## M25 junction 10/A3 Wisley interchange

### 9.58 Applicant's Response to the Examining Authority's Second Written Questions

<b>Rule Number:</b>	Rule 8(1)(b)
<b>Planning Inspectorate Scheme Reference</b>	TR010030
<b>Application Document Reference</b>	TR010030/9.58
<b>Author:</b>	M25 junction 10/A3 Wisley interchange project team, Highways England and Atkins

<b>Version</b>	<b>Date</b>	<b>Status of Version</b>
Rev 0	3 March 2020	Deadline 5

#### 9.61 EXISTING AND PROPOSED ACCESS POINTS FOR THE SPA (RESPONSE TO ExQ 2.4.12)

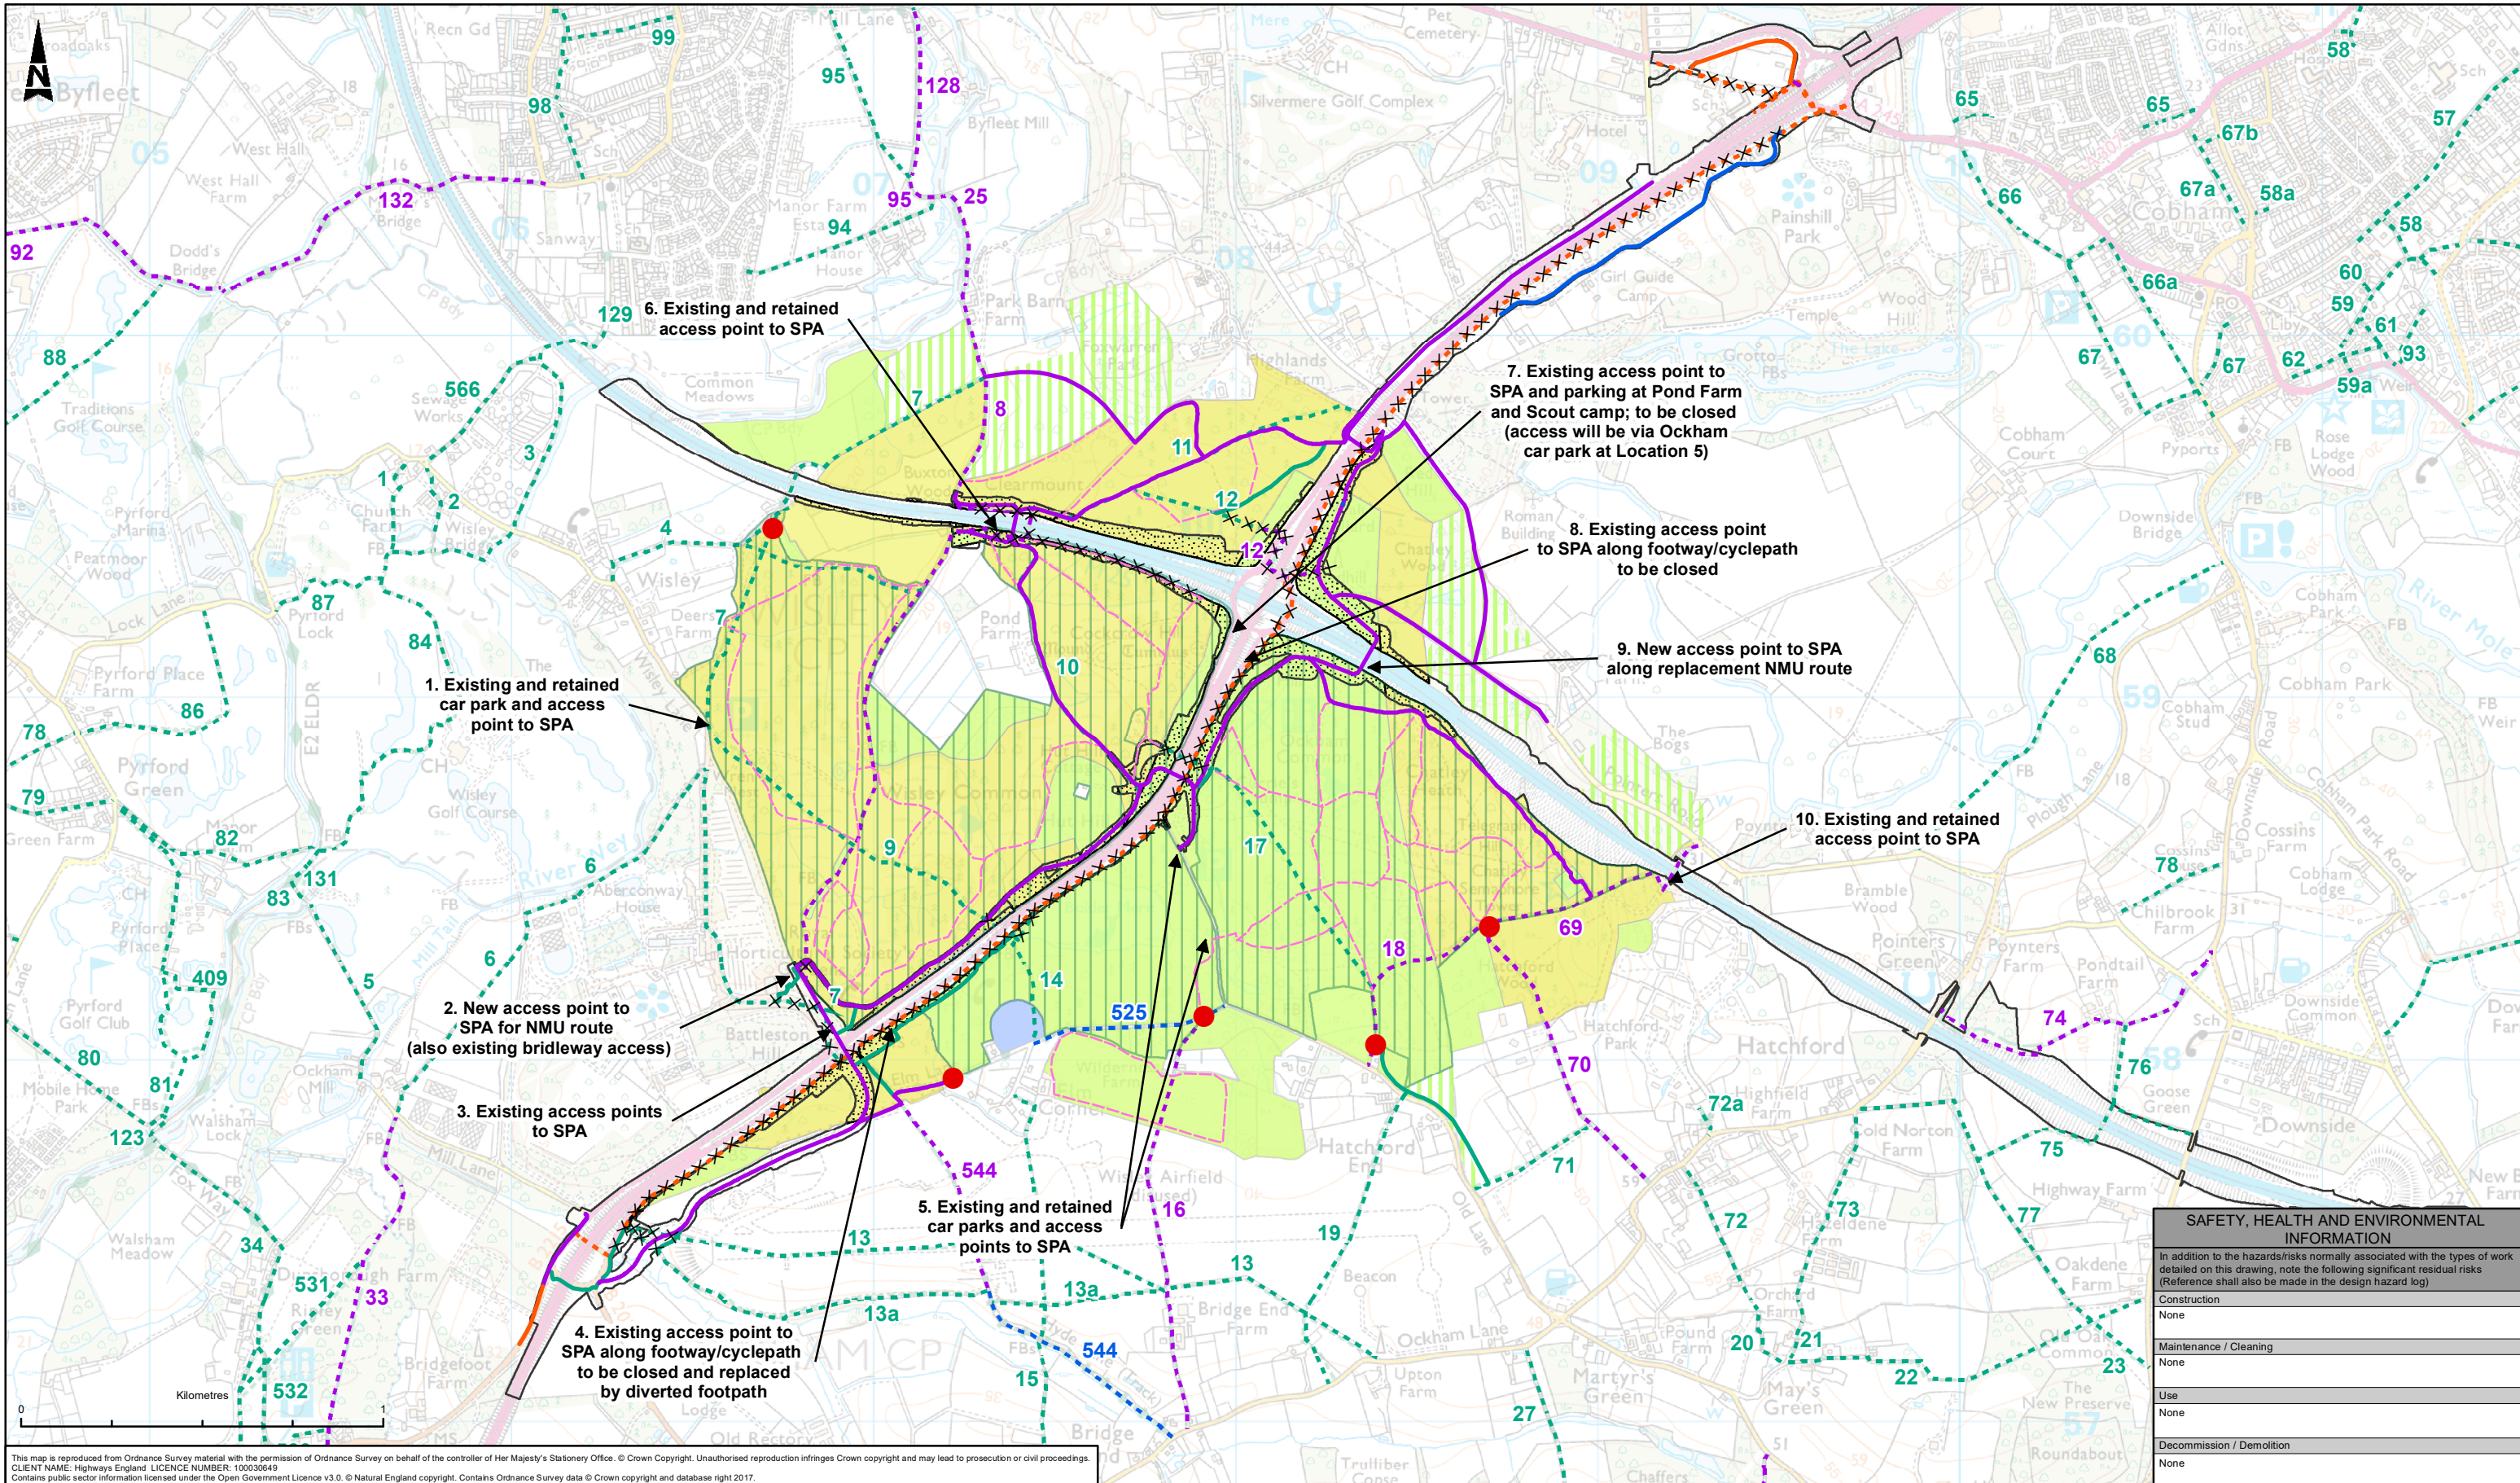
2.4.12	Applicant	In your response to written representations [REP2-014] you state that the Proposed Scheme “ <i>may increase recreational</i>	As explained in paragraphs 7.2.105 to 7.2.116 of the Habitats Regulations Assessment: Stage 2 [APP-043], the Scheme will not improve access to, or

Question Number	Question to:	Question	Highways England Response
<b>4. Biodiversity</b>			
		<p><i>activity in the wooded fringes of the SPA and along a track already well used but will not facilitate increased public accessibility into the open heathland parts of the SPA.” You provide additional clarification of this in [REP4-007]. However, please explain why increased provision for non-motorised users would not have an increased potential for increased recreational access to other parts of the SPA beyond the wooded fringes and provide a plan to indicate where the location of the public access point(s) in or adjacent to the wooded fringes of the SPA would be.</i></p>	<p>car park options for, the SPA.</p> <p>A supporting figure has been submitted alongside the Applicant’s response at Deadline 5 showing the existing and proposed access points to the SPA, with HE document reference TR010030/EXAM/9.61.</p> <p>Visitors can currently gain access to the SPA via car parks on Wisley Lane (Location 1. on the submitted figure) and Old Lane (Location 5. on the submitted figure). This arrangement will not change. There are no other formal car parks available for gaining access to the SPA.</p> <p>Therefore, the operation of the Scheme is not expected to result in changes to the numbers of visitors to the Thames Basin Heaths SPA or the way in which visitors gain access to the SPA.</p> <p>The Scheme includes provision for a largely new non-motorised user (NMU) route within the SPA through Ockham Common and Wisley Common, which will run through the fringe of retained woodland for the most-part and will fall outside the existing heathland areas where the SPA qualifying species occur. This NMU route will be a direct replacement for the existing footpath/cycleway that runs along the A3 beside the SPA and currently provides an access to and from the SPA. Two other bridleways are proposed within the SPA, which were selected because these NMU routes already exist and are already signposted for use by horse riders. The new and upgraded NMU routes are shown in purple on the submitted figure as ‘Proposed Public Bridleway’.</p> <p>The existing footway/ cycle path that runs along the A3 beside the SPA will be closed, with the access into the SPA from Elm Lane replaced by a diverted footpath (Location 4. on the submitted figure).</p> <p>The existing footway/ cycle path currently allows access to the SPA from the south at two existing locations on either side of the A3 (Locations 3 and 4. on</p>

Question Number	Question to:	Question	Highways England Response
<b>4. Biodiversity</b>			
			<p>the submitted figure). These two access points will be replaced with a single access point (Location 2. on the submitted figure), which will link the replacement NMU route to the existing tracks through Wisley Common. This access point will replace the existing bridleway access. The bridleway route through Wisley Common will follow the existing access track to Pond Farm which falls outside the existing heathland areas where the qualifying species occur. The access to this bridleway through Wisley Common from the north of the SPA will remain broadly the same via the replacement Clearmount bridge (Location 6. On the submitted figure).</p> <p>It is the utilisation of the replacement NMU route through Ockham Common and Wisley Common by existing users that is referred to in Applicant's Comments on Written Representations [REP2-014], when it is noted that recreational activity may increase within the wooded fringes of the SPA. As the access and parking will not change as a result of the Scheme, any increase in use of this NMU route would be as a direct result of visitors being drawn away from the heathland areas, or users being displaced from the existing footway/ cycle path alongside the A3.</p> <p>Ockham Common is currently accessed from the north via Hatchford Park bridge close to the Semaphore Tower (Location 10. on the submitted figure) and by a pedestrian crossing at junction 10 (Location 8. on the submitted figure). The access via Hatchford Park bridge will remain in place, but the pedestrian crossing will be replaced by an overbridge linking the SPA to existing common land and the replacement land at Chatley Farm (Location 9. on the submitted figure). There is no formal parking in this location, so it is considered that most recreational visitor movement across this overbridge would be travelling away from the SPA, as visitors from the formal car parks leave the SPA to cross the overbridge to visit the replacement land at Chatley Farm and return.</p>

Question Number	Question to:	Question	Highways England Response
<b>4. Biodiversity</b>			
			<p>Pond Farm and the Scout camp on Wisley Common are currently accessed off the M25 slip (Location 7. on the submitted figure). This access will be closed, and future access will be via the Ockham Common carpark (Location 5. on the submitted figure) and over Cockcrow Bridge.</p> <p>All access points are shown on the submitted figure. In addition to the points referred to specifically in this response, there are several additional access points to the SPA that will remain unchanged as a result of the Scheme. These are depicted as red dots on the submitted figure.</p> <p>Overall, the number of access points to the SPA will be reduced. This is as a result of the closure of the footway/cycle path access to the south of the SPA (Location 4. on the submitted figure), with the new NMU access being consolidated with an existing bridleway (Location 2. on the submitted figure), and also the closure of the M25 slip access (Location 7. on the submitted figure). The car park arrangements will remain unchanged.</p> <p>Due to access to the SPA not improving on account of the Scheme, it is predicted that the number of recreational visitors will not increase as a result of the Scheme. As the environmental works establish and mature in the years after completion, there will be a larger area for recreational visitors to explore in total as a result of the replacement land outside the SPA, which will help diffuse, and potentially reduce, the visitor pressure on the existing heathland areas within the SPA. Therefore, due to the provision of additional NMU routes away from sensitive heathland areas and the provision of replacement land outside the SPA, the recreational pressure on the heathland areas will not increase and may even reduce as a result of the operational Scheme.</p> <p>Due to there being no predicted increase in recreational disturbance as a result of the Scheme, there will be no adverse effects on the integrity of the SPA as a result of increased recreational disturbance. The findings of the statement to inform the appropriate assessment, with regards to recreational</p>

Question Number	Question to:	Question	Highways England Response
<b>4. Biodiversity</b>			
			<p>disturbance, have been reviewed and agreed with Natural England, RSPB and Surrey Wildlife Trust.</p> <p>Therefore, increased provision for non-motorised users would not have an increased potential for increased recreational access to other parts of the SPA beyond the wooded fringes because the increased provision is to areas outside of the SPA.</p>
